Draft Submission to Proposed State Significant Development

(SSD 9210)

Proposed Primary School
17-19 Kosovich Place, Cecil Park

5 December 2018

SITE ELEVATIONS - NORTH & SOUTH

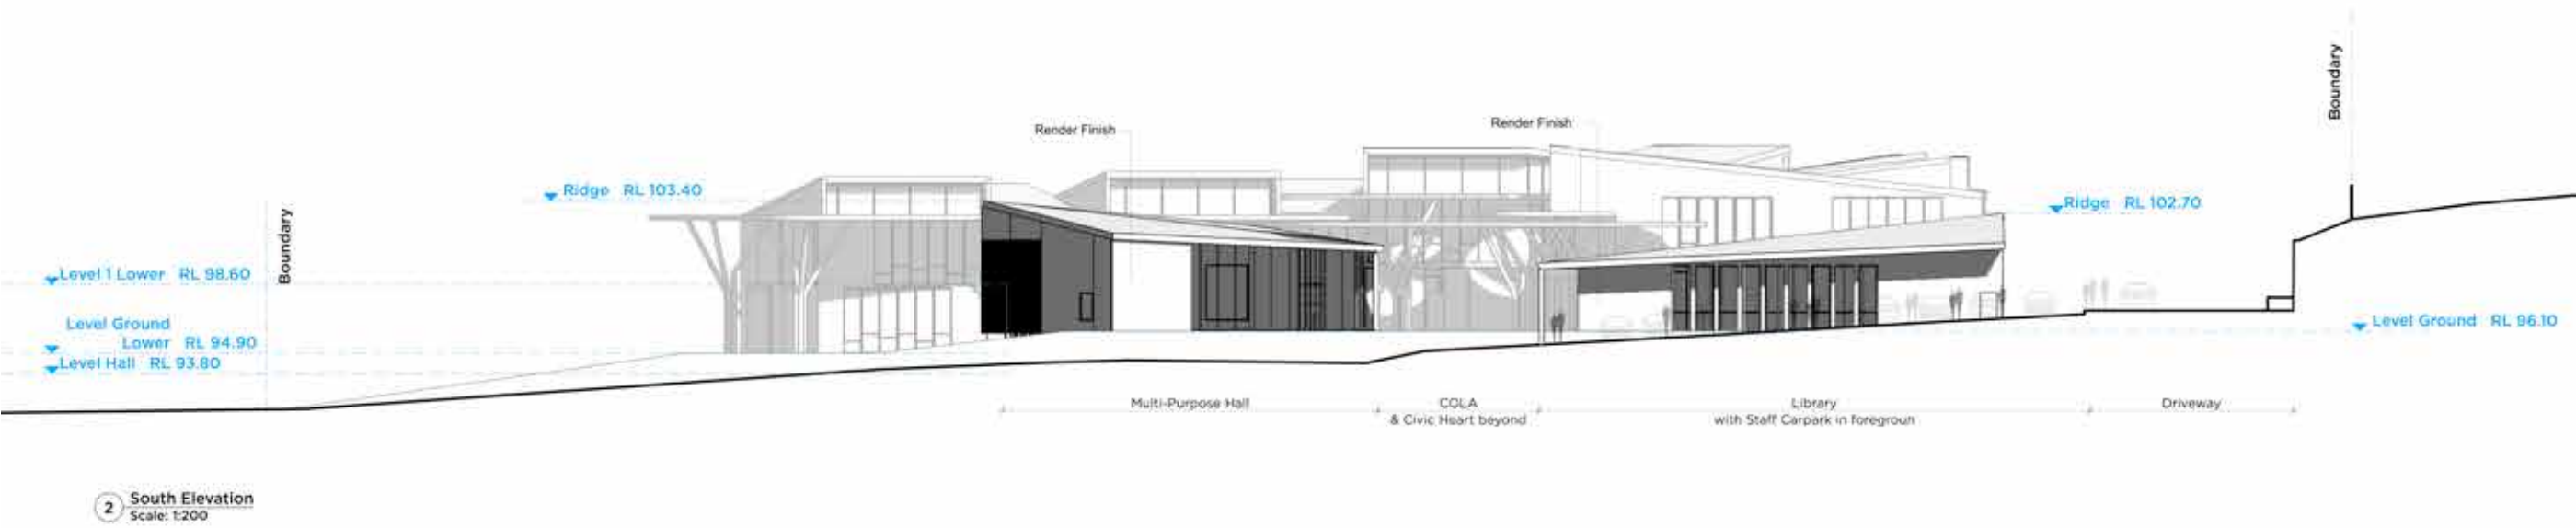
Concern is raised that the proposed building design being a single mass, located in close proximity to the eastern boundary, is not considered to be in character with the rural locality. It is noted that the eastern elevation of the building is approximately 74.8m in length which is vastly different from the other built forms within the area. Accordingly, the proposal would be inconsistent with the objectives of the zone, particularly "To ensure that development is sympathetic to the rural environment and minimises risks from natural and man-made hazards".

- The proposal seeks to breach the maximum building height development standard within the FLEP 2013 by approximately 3.8m or 42.2%. Accordingly, an assessment of the breach indicates that it is not considered that there are sufficient environmental planning grounds to support a variation proposed and therefore it is not considered that the proposal would be in the public interest.

DRIVEWAY AND KISS & DROP ZONE

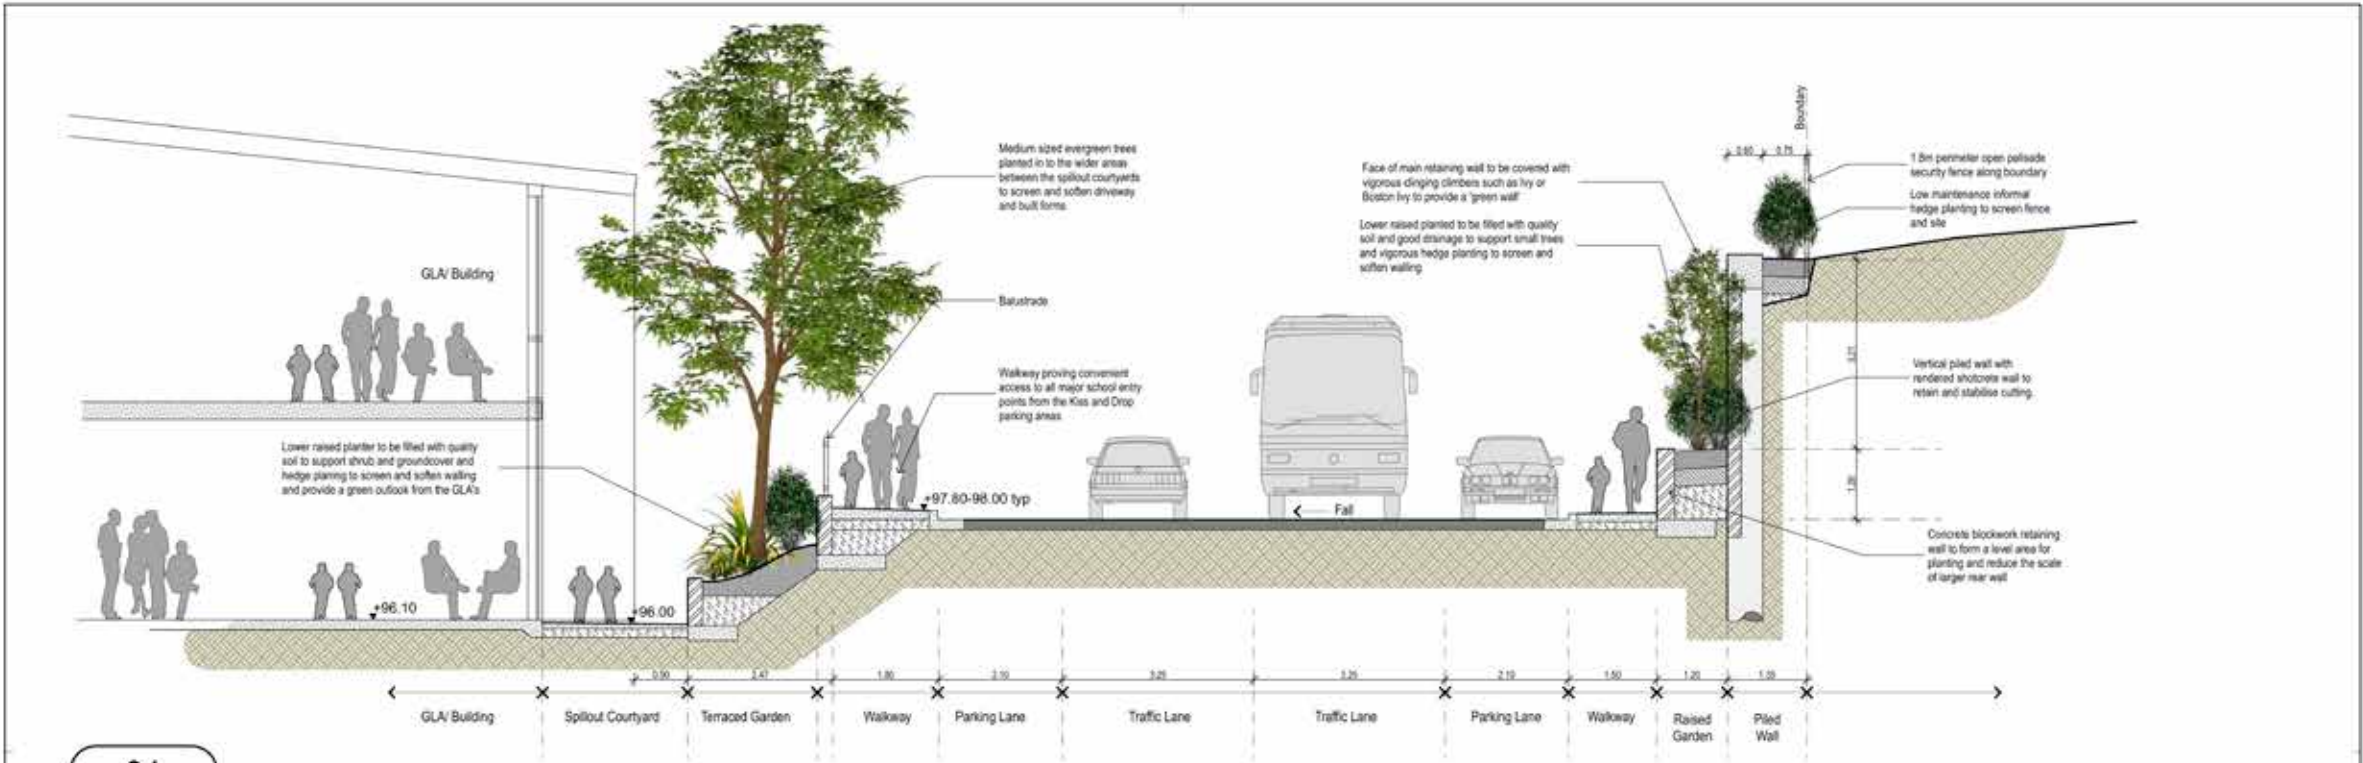
- The 20 metre eastern setback proposes 30 kiss and drop of point spaces, additional car parking for staff and outdoor learning areas. The location of the spaces, drop off points and outdoor learning areas is likely to result in unacceptable amenity impacts to the eastern neighbouring property.

- The proposed 30 kiss and drop off spaces is unlikely to be sufficient in order to accommodate up to 665 school children and staff onsite. This will likely result in unacceptable queuing and parking within Kosovich Place.

DRAWING TITLE				
EARTHWORKS CUT-FILL PLAN				
PROJECT NO.	PLANSET NO.	RELEASE NO.	DRAWING NO.	REVISION
P1705798	PS03	R05	PS03-C500	E

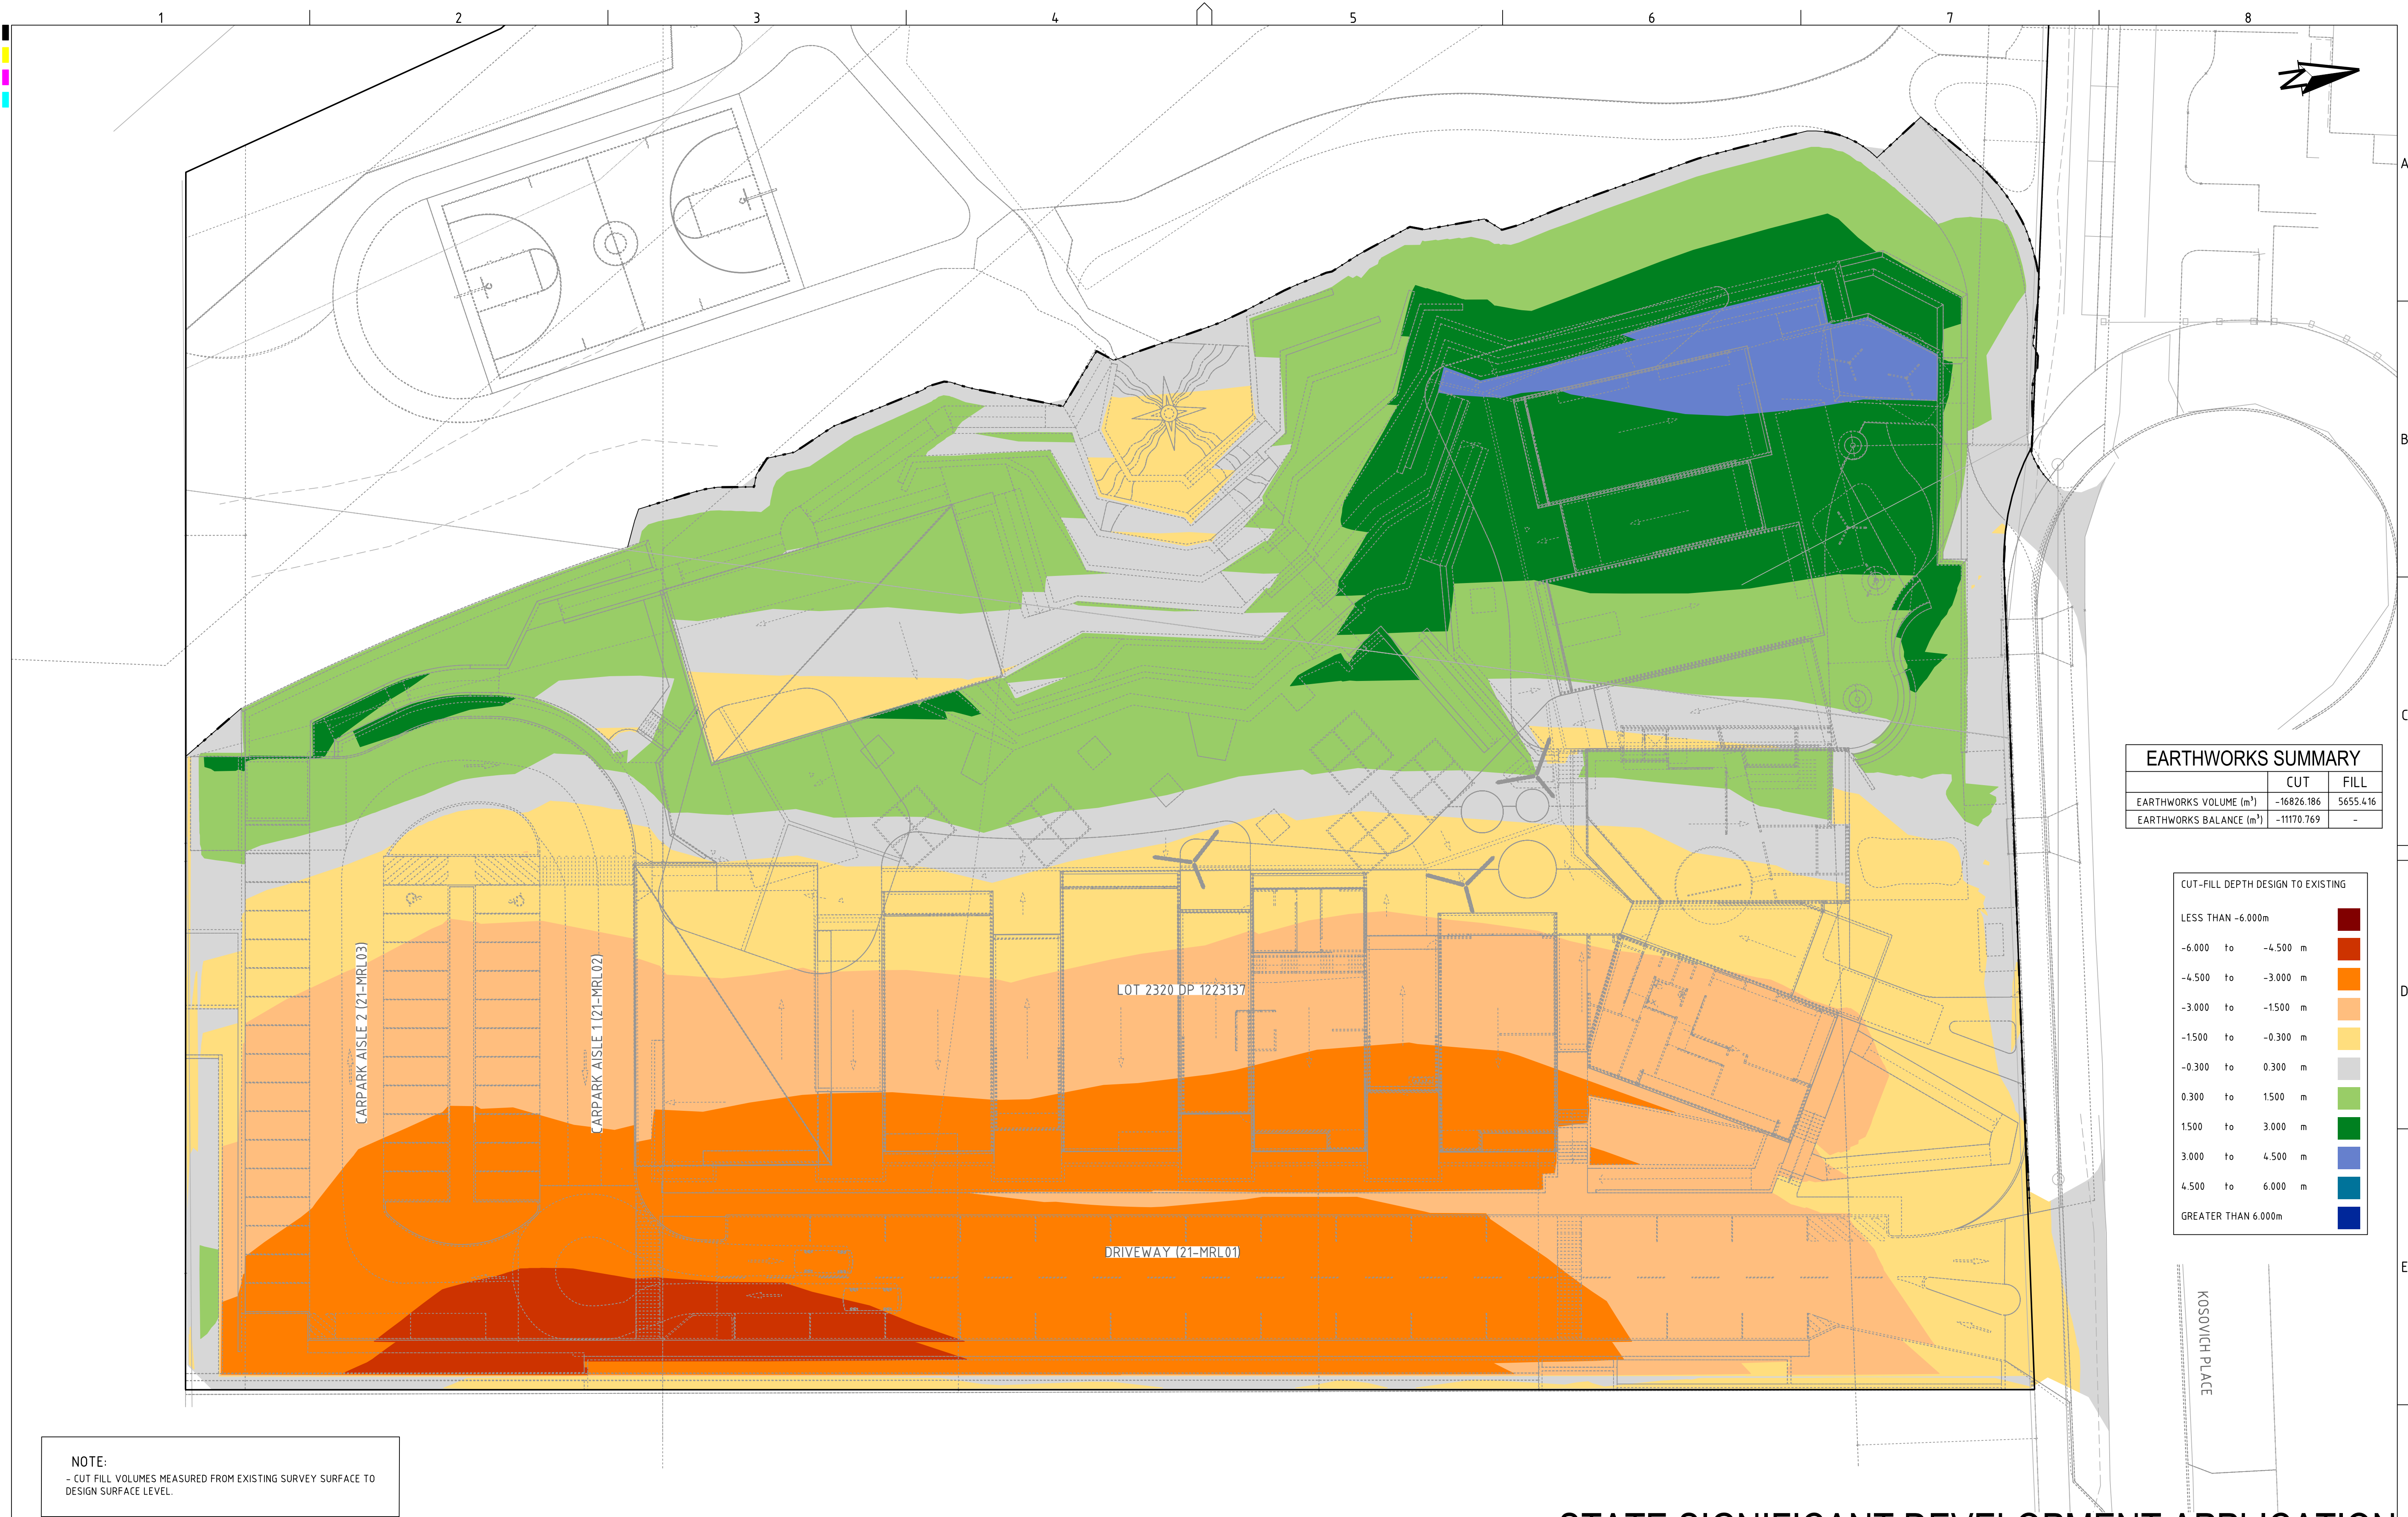
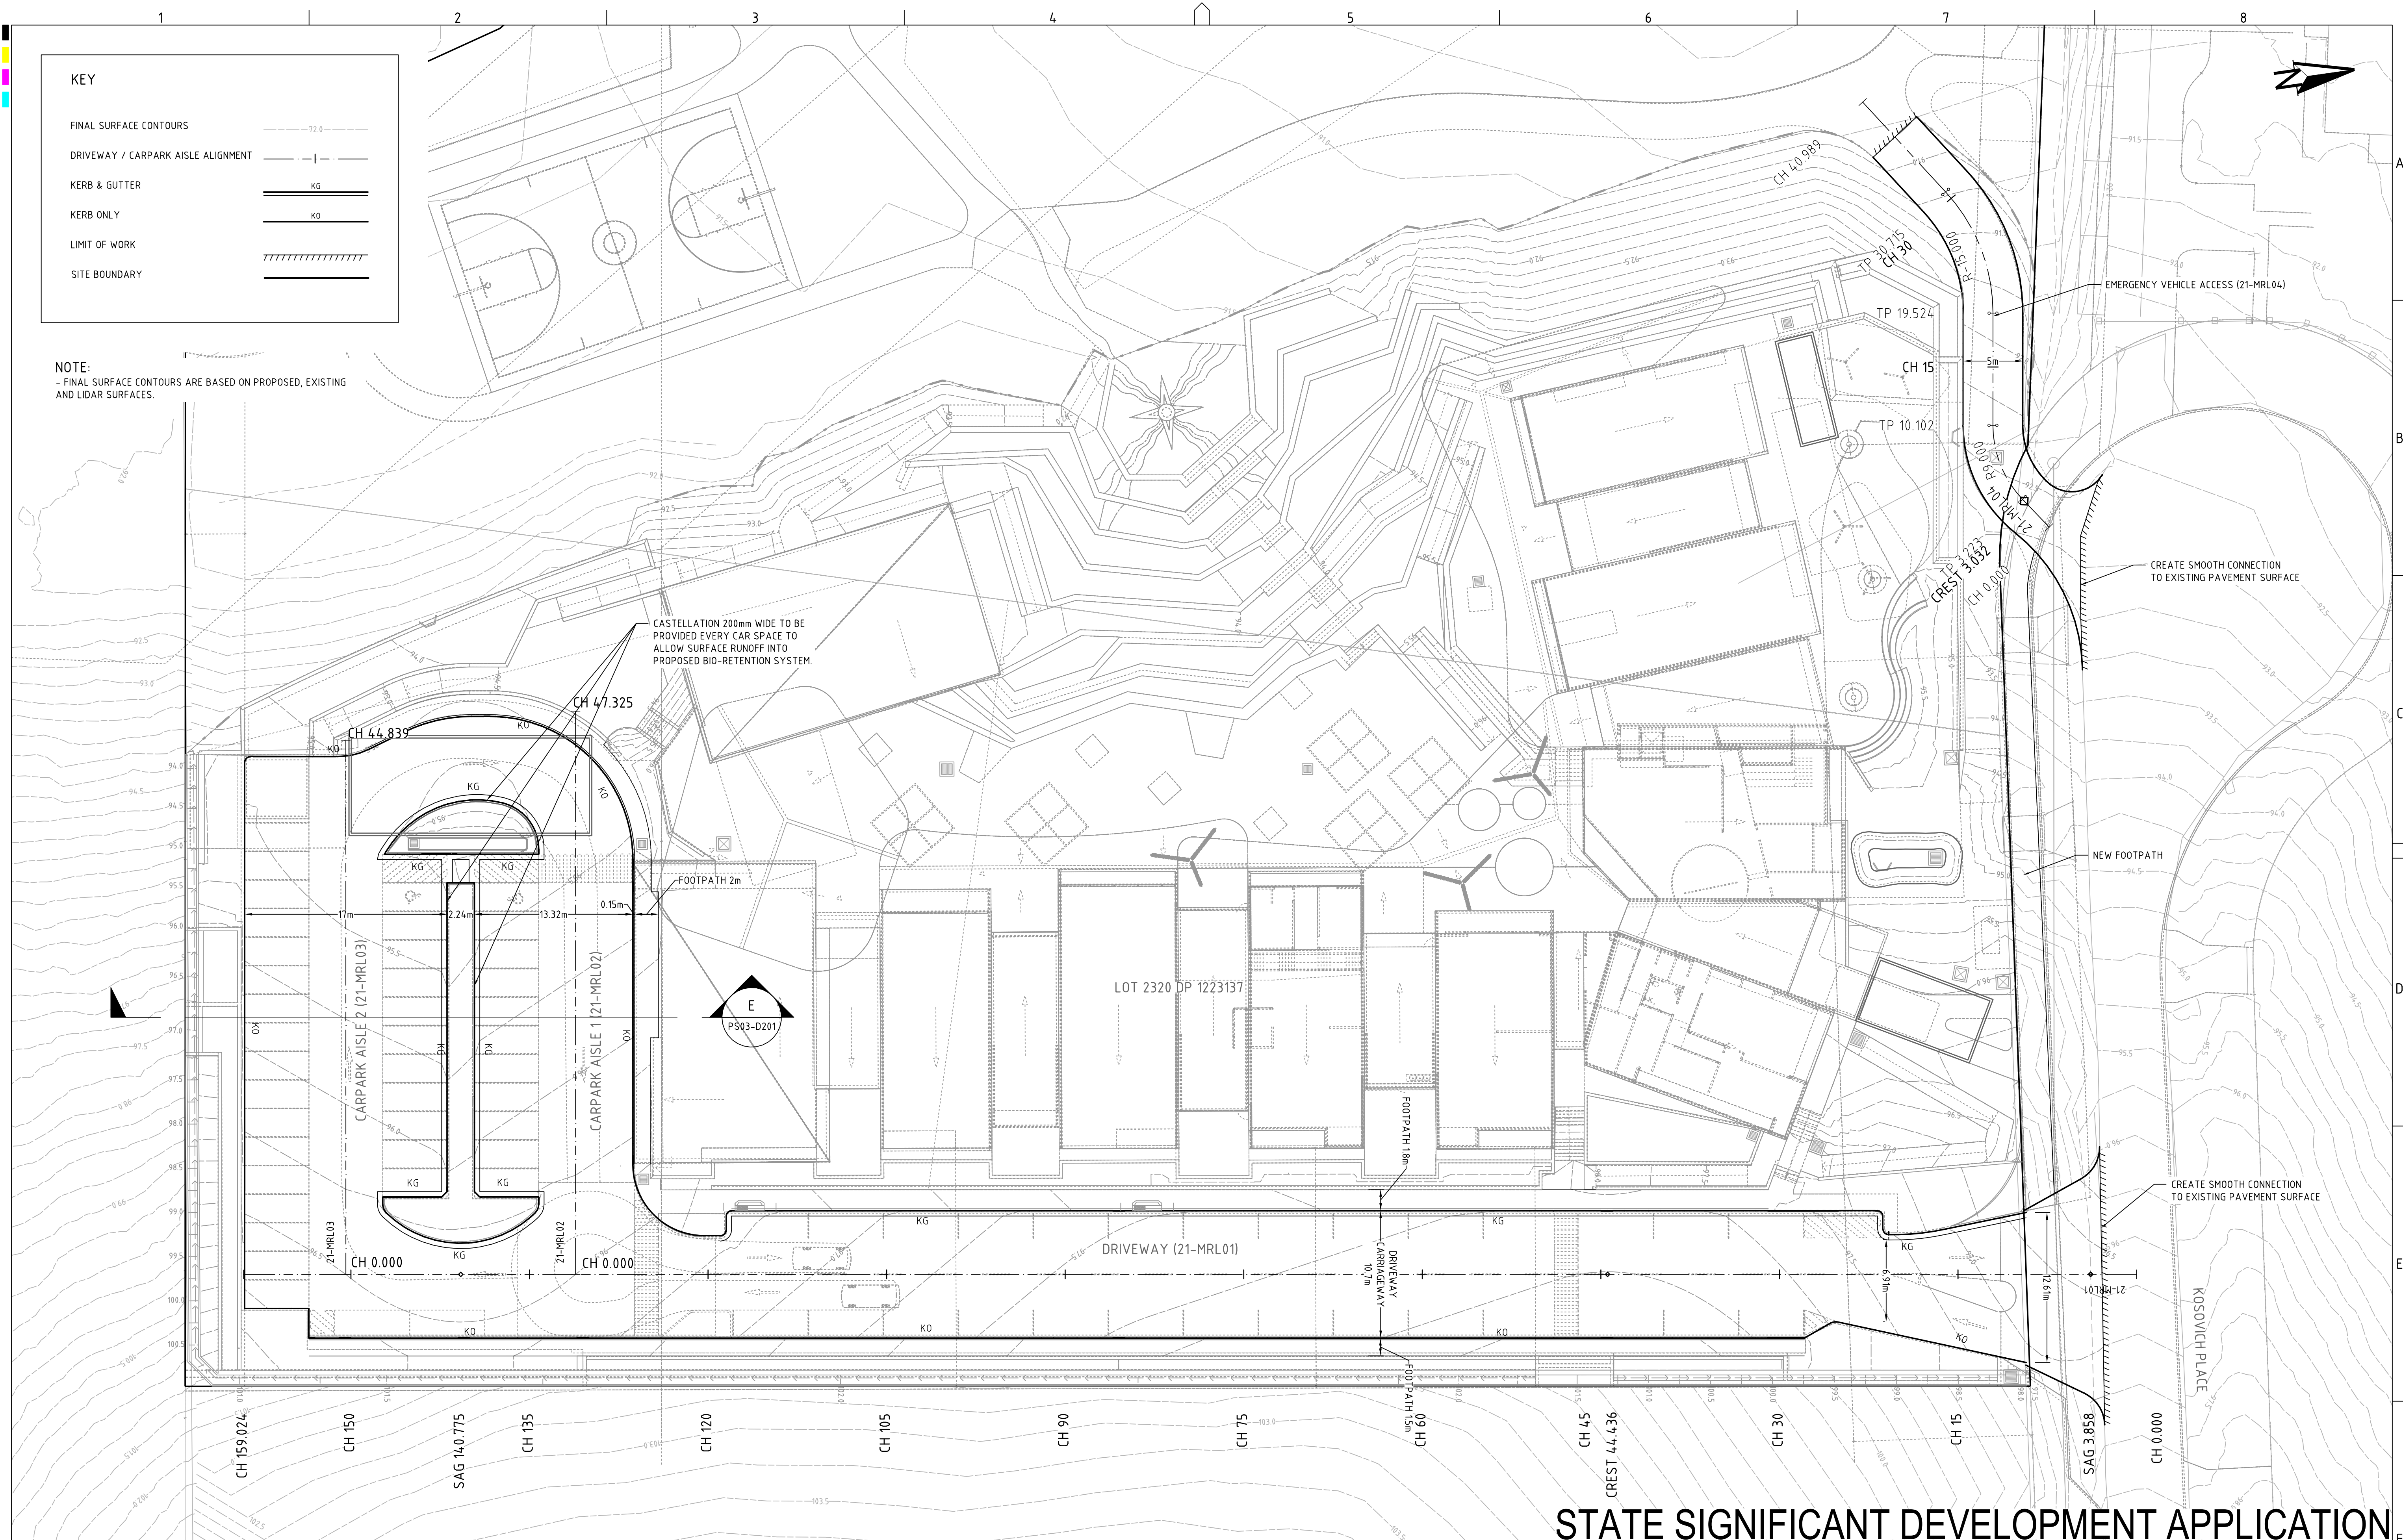
- The proposed development results in significant cut and fill particularly within the eastern portion of the site. The architectural plans show approximately 4.4m level difference between the eastern neighbour and the subject site which is significant. This is not considered in character with the rural area. This is a concern that was expressed by the Design Review Panel.
